Addendum No. 1

RE: Contract ID: C201362
WBS # 39695
Moore County
NC 24/27 from West of NC-22
to East of NC-705

December 21, 2004 Letting

**TYPICAL SECTION NO. 1**

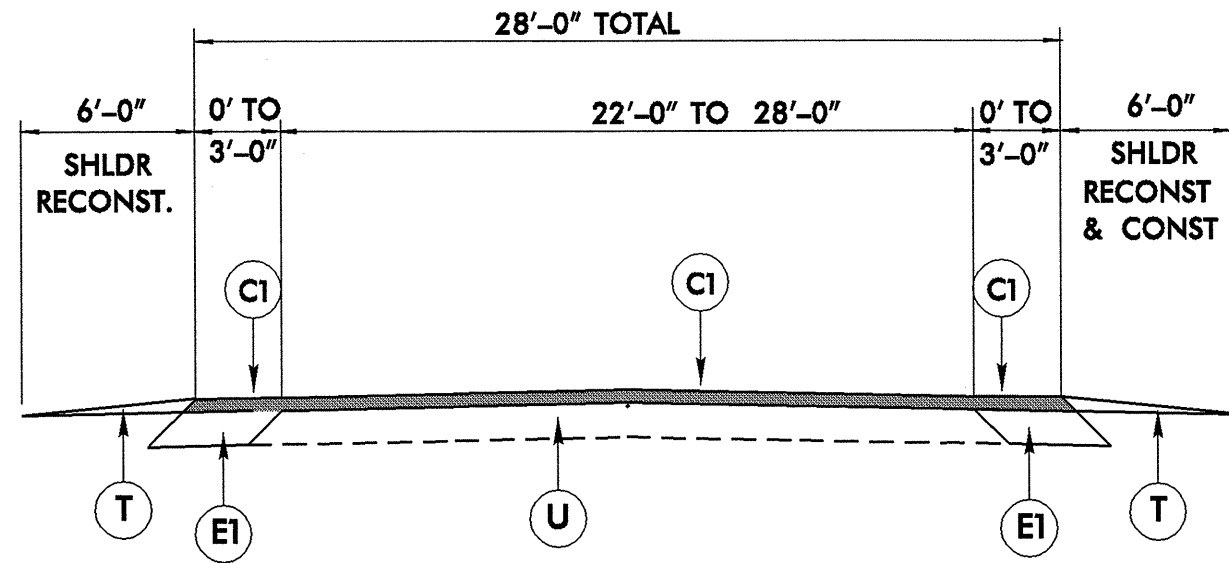
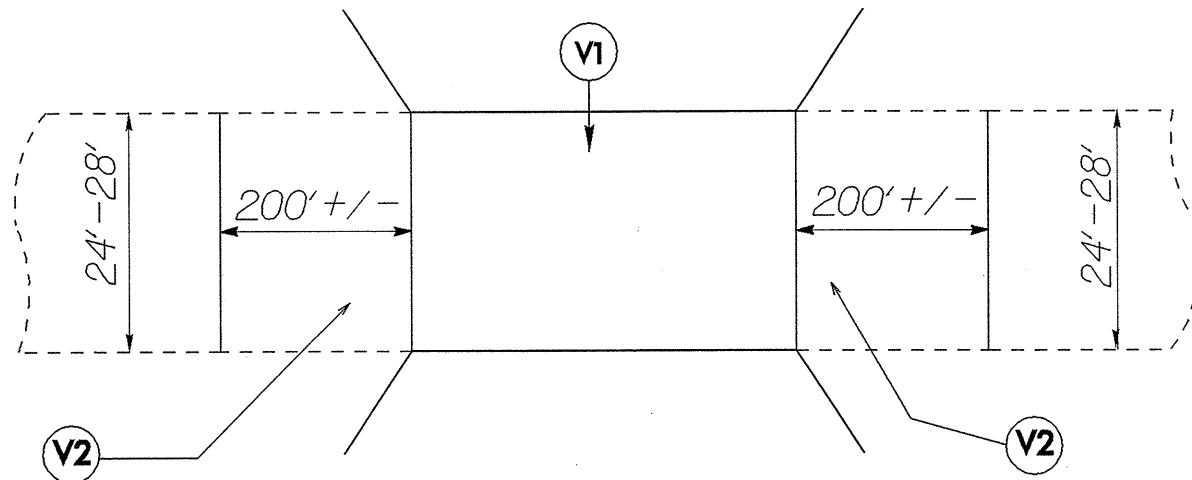
On Sheet No. 2, the Typical Section No. 1 has been revised and a Note added. Please void Sheet No. 2 in your sketch maps and staple the revised Sheet No. 2 thereto.
